Your Ref: OWPC25185
Our Ref: FG/135/19/PL 06-11-2019
Please ask for:
Zac Denton

Demolition of a silo & erection of an office building (B1(a) Business), 6 No. parking spaces for office workers & erection of boundary fencing.

Silo at Former McIntyre Nursery Littlehampton Road Ferring

Thank you for your internet representation made on 4th December 2019 which has been recorded as '**an objection**' with the comments as follows:

TITLE: Proposed Plans & Elevations

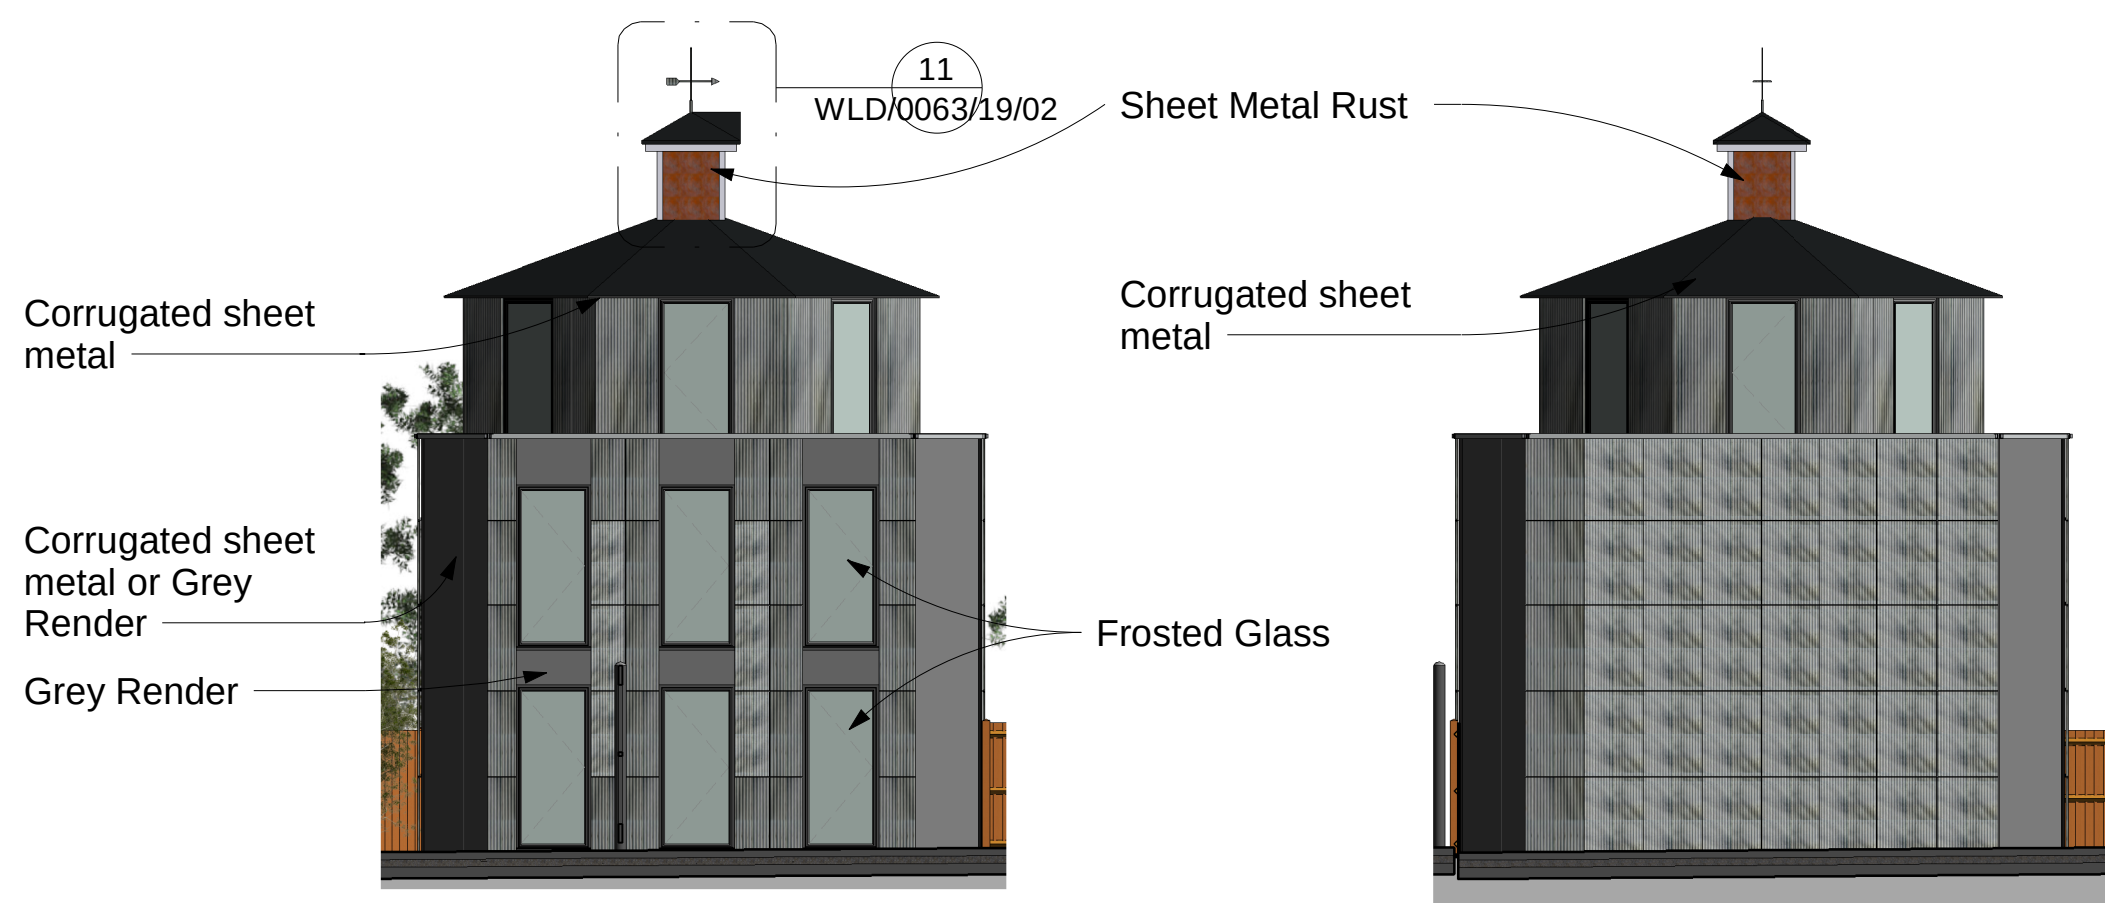
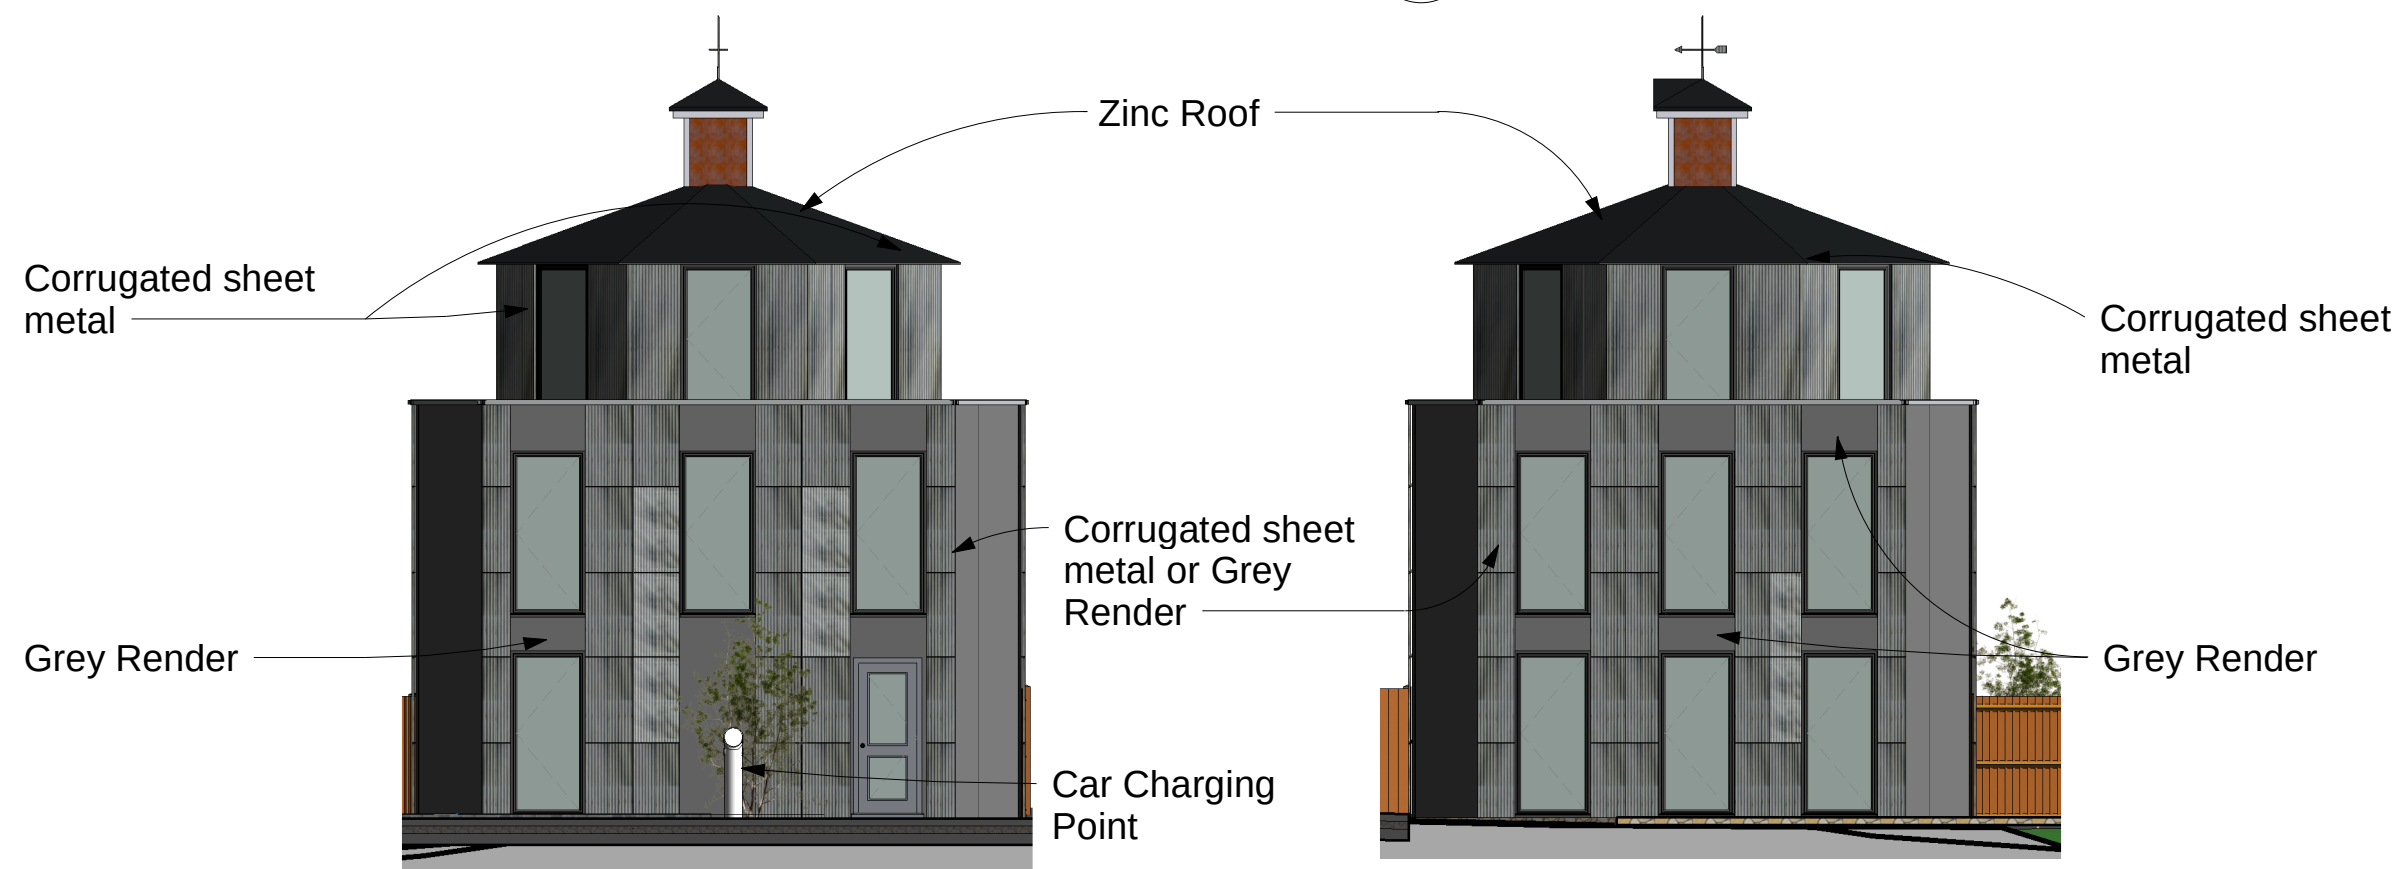
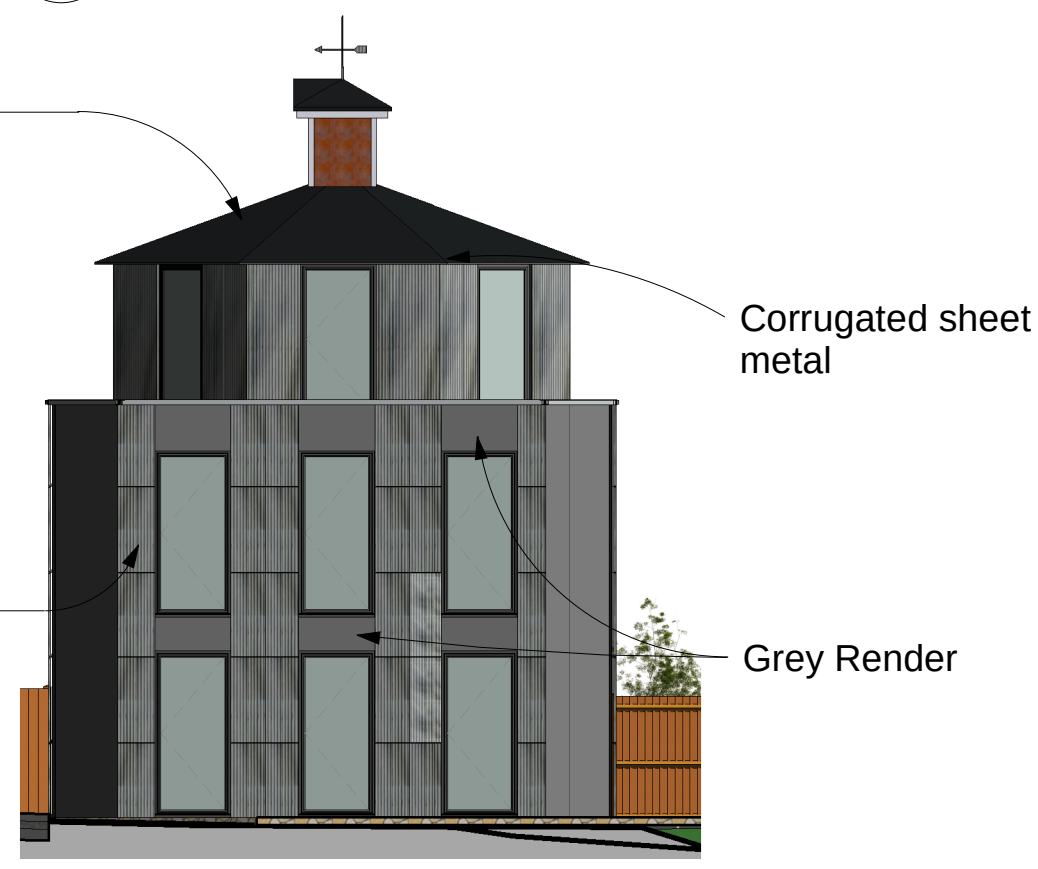
I've looked at the plans and pictured elevations of the proposed 3 storey Office Building replacing the previous silo. This is a rural location and to place this building that looks like one you might come across in the Industrial Area of Brooklyn, New York, would be anathema. Some regard must be paid to the surroundings so that they are not destroyed. Please carefully consider this for rejection. Thank you.
